Pear tree Hill Solar Farm

Environmental Statement Addendum

Revision 2 (tracked)

Application Document Ref: EN010157/APP/8.2

Revision 2

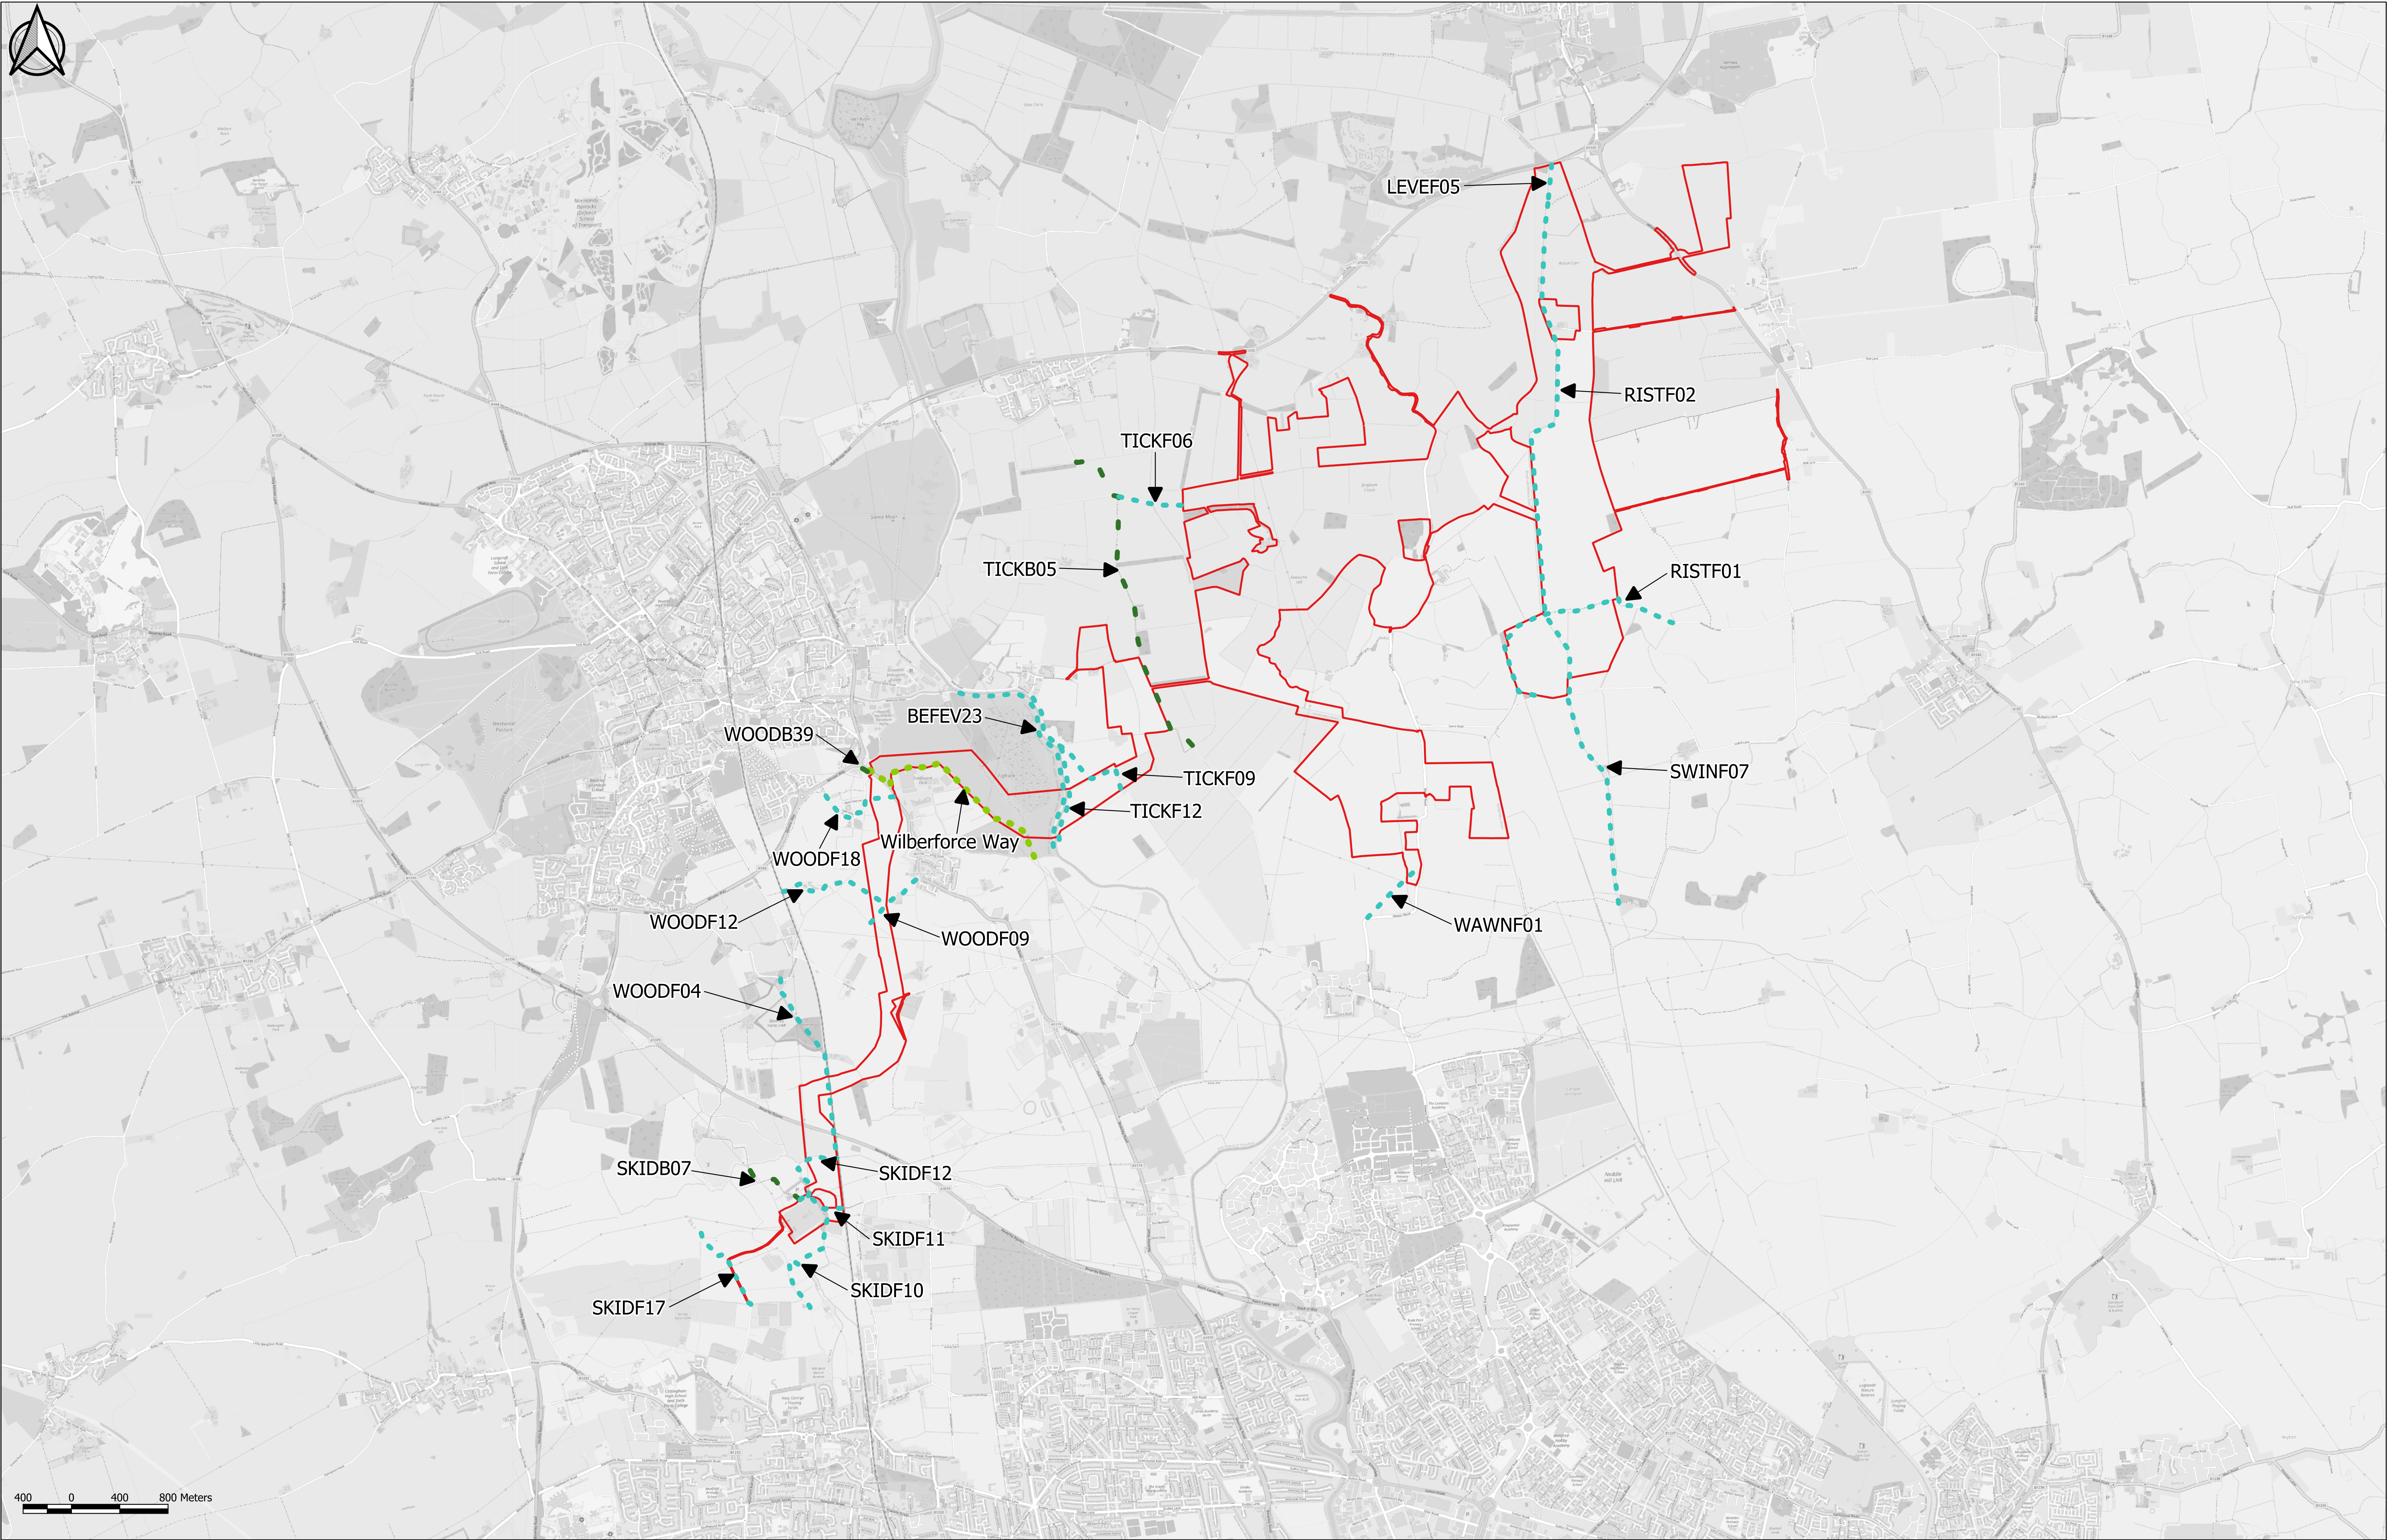
Document reference	Reason for amendment	ES Amendment July 2025
ES Volume 3, Figure 14.3: Public Rights of Way and Long Distance Paths Within and Adjacent to the Proposed Development [APP-091]	Figure 14.3 requires amendment to reflect the removal of plots 10-4, 10-5 and 10-6 as part of change/correction 2.	
ES Volume 3, Figure 14.4: Link Sensitivity [APP-092]	Figure 14.4 requires amendment to reflect the removal of plots 10-4, 10-5 and 10-6 as part of change/correction 2.	
ES Volume 3, Figure 15.1: Other Existing and/or Approved Development [APP-093]	Figure 15.1 requires amendment to reflect the removal of plots 10-4, 10-5 and 10-6 as part of change/correction 2.
